Charlotte Storm Water
600 East Fourth Street
Charlotte, N C 28202-2844

Rezoning Petition Review

Rezoning Petition #: 20-167

Location of Property: Approximately 3.08 acres located on the west side of Bancroft St, north of 24th St and east of Graham St.

SCHEMATIC  
SITE PLAN  
SCALE: 1" = 30'

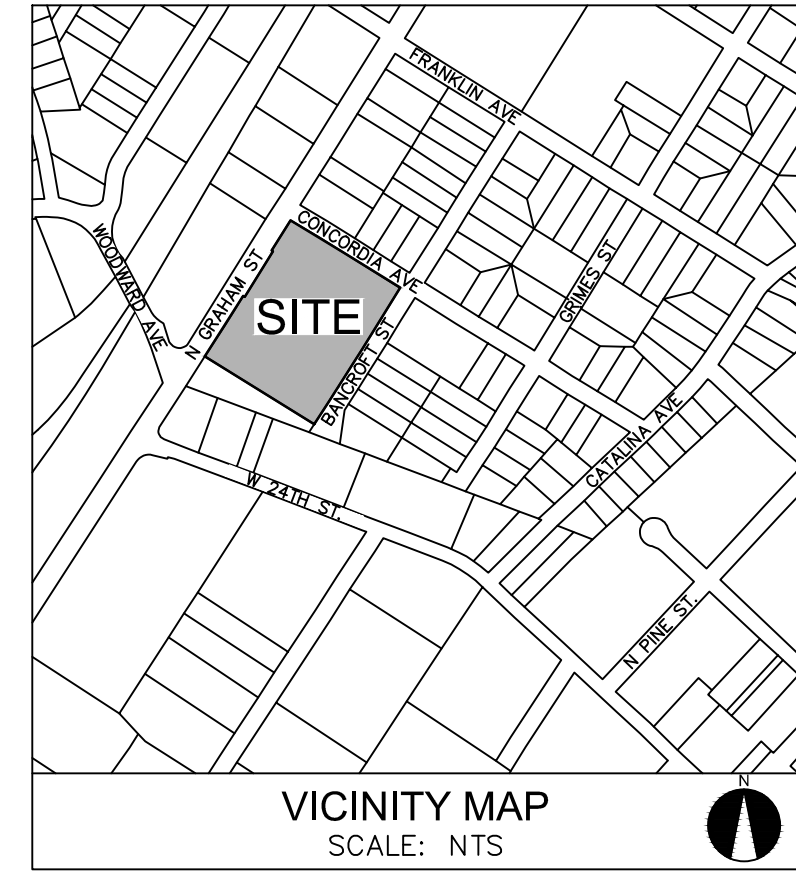
This property drains to Upper Little Sugar Creek, which is an impaired/degraded stream, and may contribute to downstream flooding. This project has the opportunity to mitigate future impacts to this stream, therefore, Storm Water recommends placing the following notes on the plan:
(I) Storm Water Quality Treatment

For defined watersheds greater than 24% built-upon area (BUA), construct water quality stormwater control measures (SCMs) designed for the runoff generated from the first 1-inch of rainfall for all new and redeveloped BUA associated with the project. SCMs must be designed and constructed in accordance with the Charlotte-Mecklenburg BMP Design Manual.

For defined watersheds greater than 24% built-upon area, control the entire volume for the 1-year, 24-hour storm for all new and redeveloped BUA associated with the project. Runoff volume drawdown time shall be in accordance with the Charlotte-Mecklenburg BMP Design Manual.

For commercial projects with greater than 24% BUA, control the peak to not exceed the predevelopment runoff rates for the 10-yr, 6-hr storm and perform a downstream flood analysis to determine whether additional peak control is needed and if so, for what level of storm frequency, or if a downstream analysis is not performed, control the peak for the 10-yr and 25-yr, 6-hour storms.

For residential projects with greater than 24% BUA, control the peak to not exceed the predevelopment runoff rates for the 10-year and 25-year, 6-hour storms or perform a downstream analysis to determine whether peak control is needed, and if so, for what level of storm frequency.
